**KIRKLEES METROPOLITAN COUNCIL
INVESTMENT & REGENERATION SERVICE**

**DELEGATED DECISION TO DETERMINE APPLICATIONS FOR
CONSENT, AGREEMENT OR APPROVAL REQUIRED BY CONDITION**

Reference No:	2024/44/90237/W
Site Address:	adjacent, Britannia Road, Golcar, Huddersfield, HD3 4QB
Description:	Discharge of conditions 3 (construction environmental management plan), 4 (public right of way), 5 (retaining walls), 6 (Phase II Report), 7 (Remediation Strategy), 9 (Remediation Validation Report) and 18 (Japanese Knotweed) of previous permission 2021/92062 for erection of 9 dwellings and associated works
Recommending Officer:	Nick Hirst

Application: 2024/90237

01 BOUNDARY WALL (FRONT) - PART ELEVATION & DETAIL SCALE 1:20

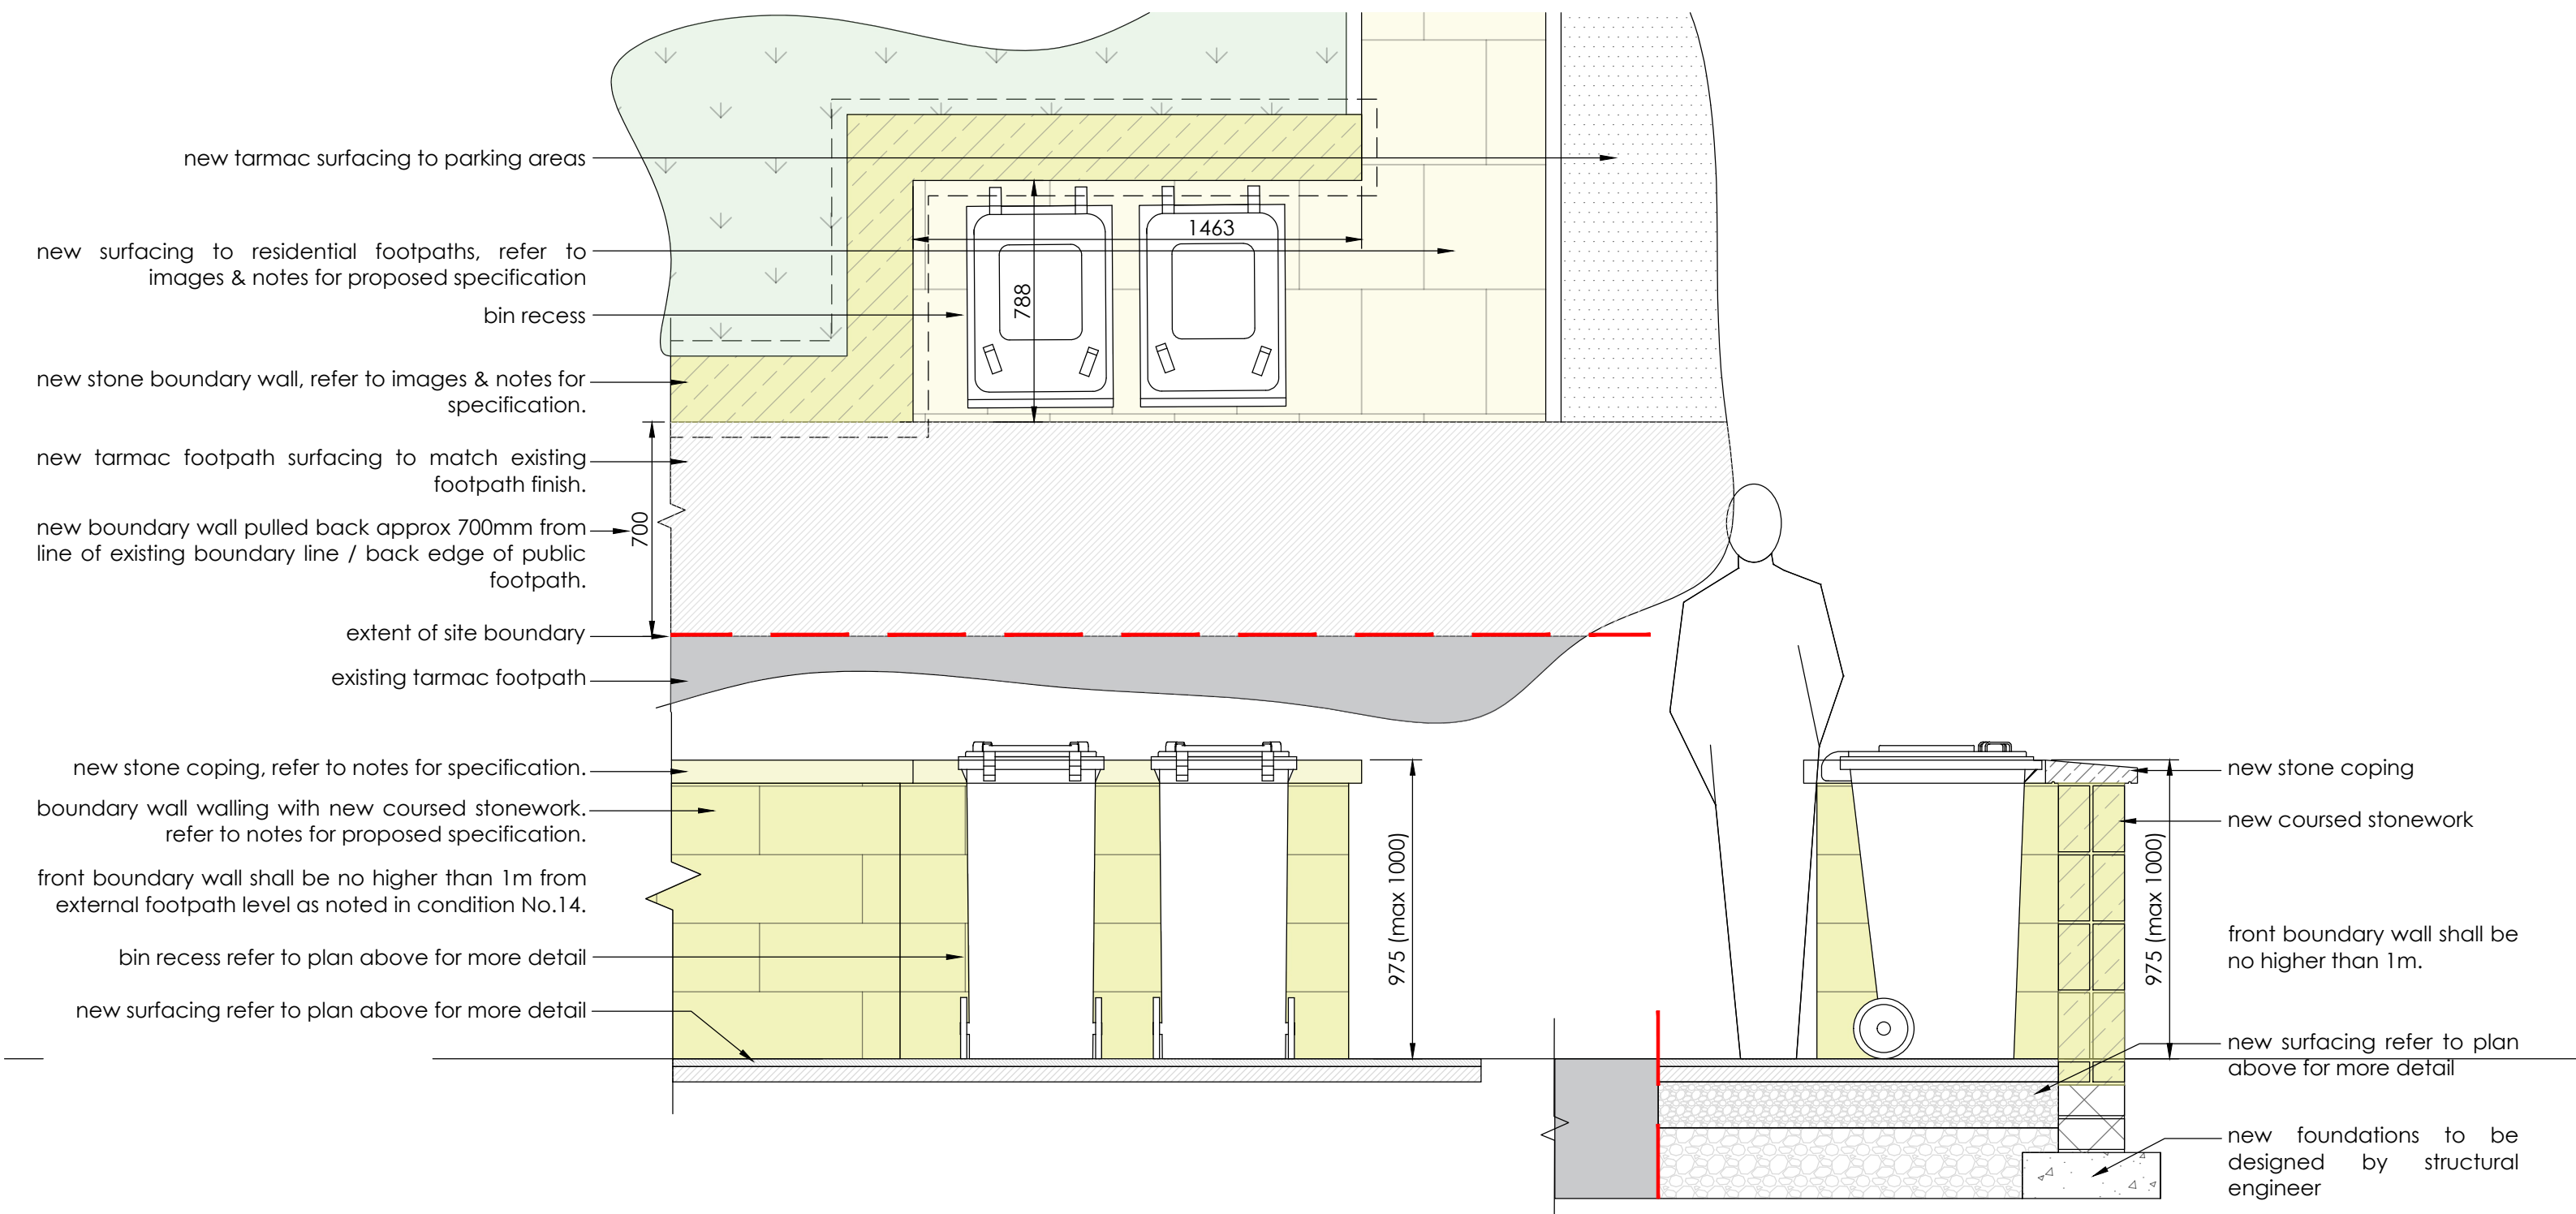
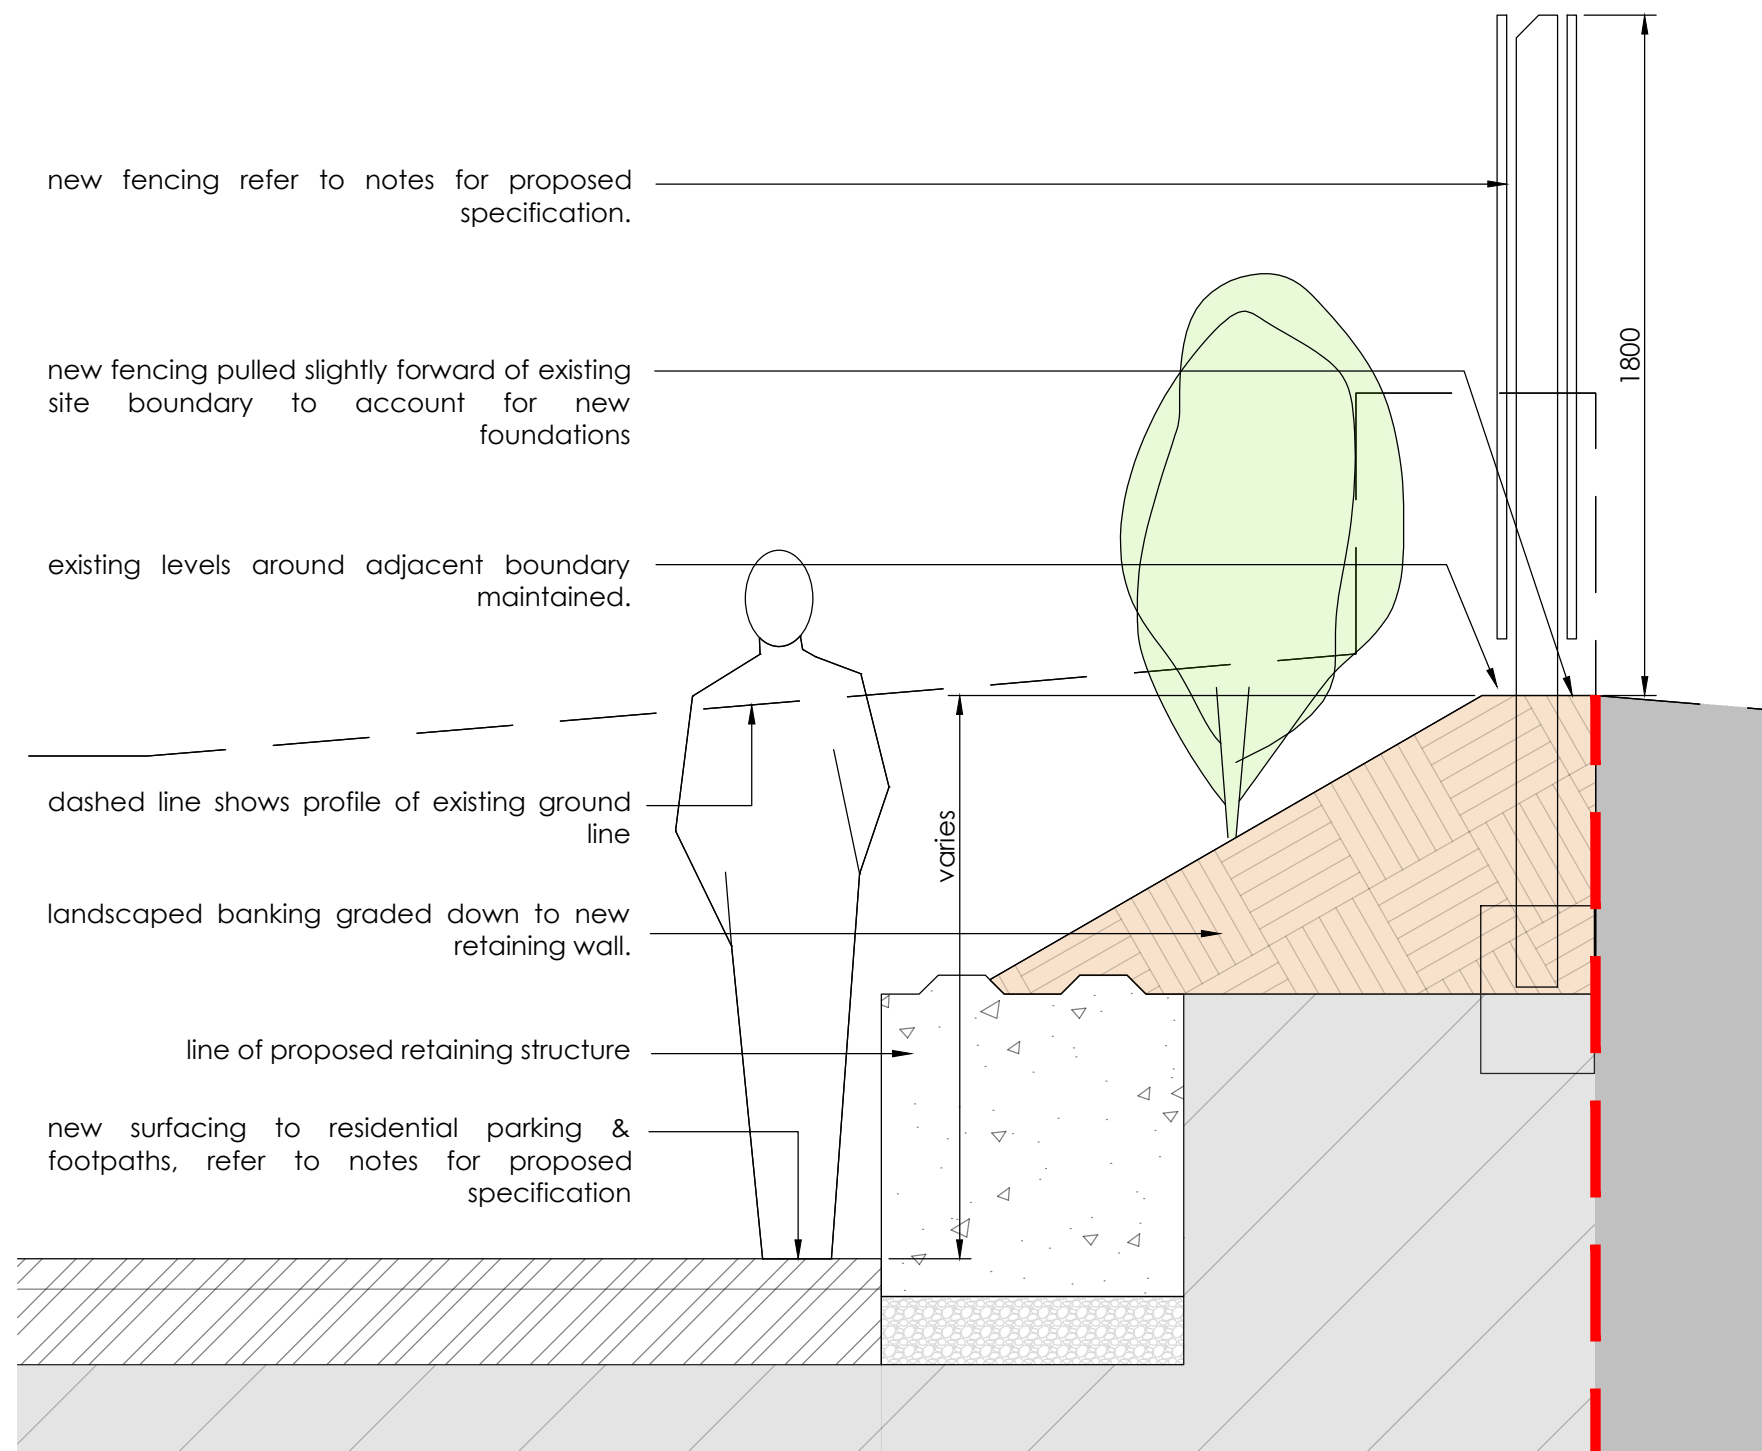
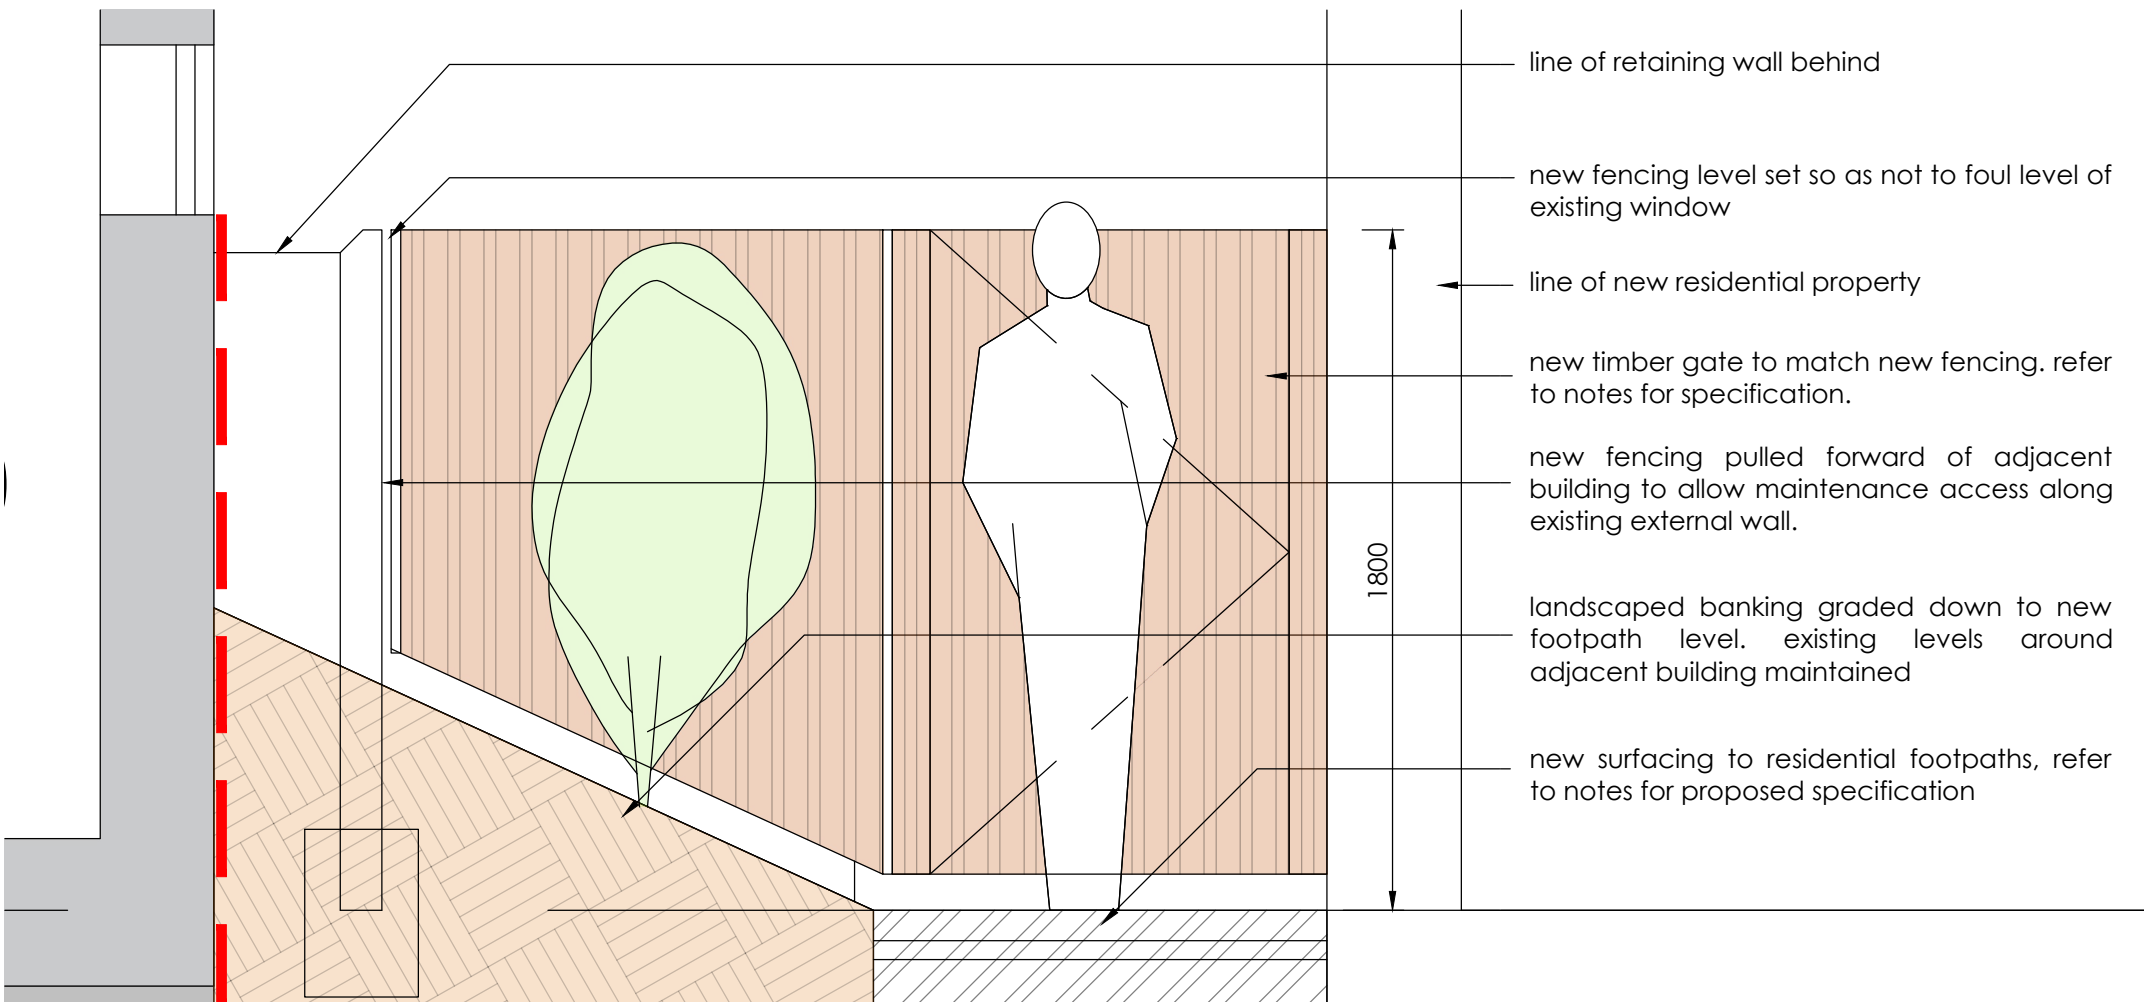
This condition requires technical and fully dimensioned sectional plans to detail the proposed engineering and retaining works, to allow officers to assess that the works would be undertaken safely and without prejudicing the stability of the highway (including PROWs). No such details have been provided and K.C. Highways (Structures) have raised an objection.

In addition to the missing details, the plans which have been submitted (including a block plan and non-dimensioned sections) indicate changes to the approved plans. This includes previous vertical retaining walls being changed to batters. It is beyond the scope of this DoC submission to amend the approved plans.

This condition requires technical and fully dimensioned sectional plans to detail the proposed engineering and retaining works, at or near the new and existing highway, to allow officers to assess that the works would be undertaken safely and without prejudicing the road network. No such adequate details have been provided.

Further to the above, the plans which have been provided indicate changes to the proposed design and method of retention / engineering works within the site from the approved plans. It is outside the scope of the Discharge of Condition process to make such amendments to the approved plans.
